Your Ref :
Our Ref : AL/31/18/NMA

Non-material amendment following the grant of AL/102/17/RES for amendment to apartment block consisting of 8 No. dwellings to include the addition of automatic opening smoke vent to rear elevation, additional windows to bathrooms & adjustment to first & second floor apartments to accommodate service riser.

Land at Nyton Rd & Northfields Lane, Westergate, & land off Fontwell Lane, Eastergate, ,

DRAWING NUMBER	REVISION
LHG 59650 - 171	A

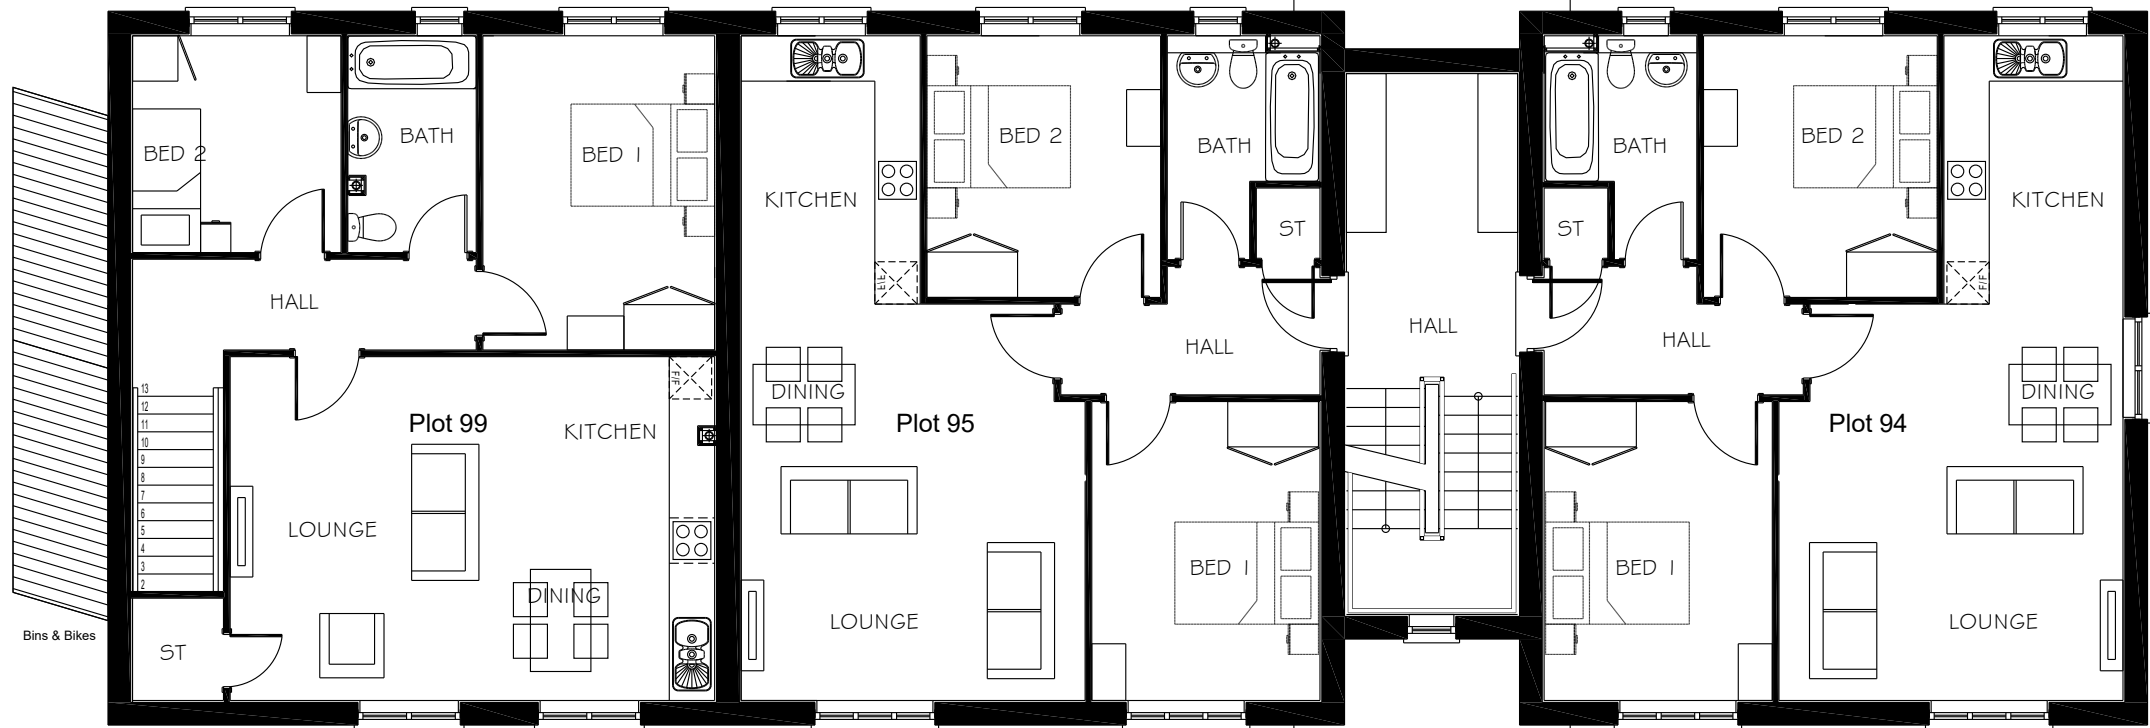
- Addition of 6 no. windows on the rear elevations serving the bathrooms serving plots 92, 93, 94, 95, 96 and 97.
- Internal alterations to the layout of the bathrooms associated with plots 94, 95, 96 and 97 as well as the first and second floor hallway.
- Addition of a roof light on the rear elevation.

Therefore, drawing nos. 'LHG 59650 - 171 A (Plans)'; 'LHG 59650 - 172 A (Plans & Elevations)'; and 'LHG 59650 - 173 A (Elevations)' replace '171 AF2 Flats (Plans)'; '172 AF2 (Plans and Elevations)'; and '173 AF2 Flats (Elevations)' and become the approved plans for AL/102/17/RES.
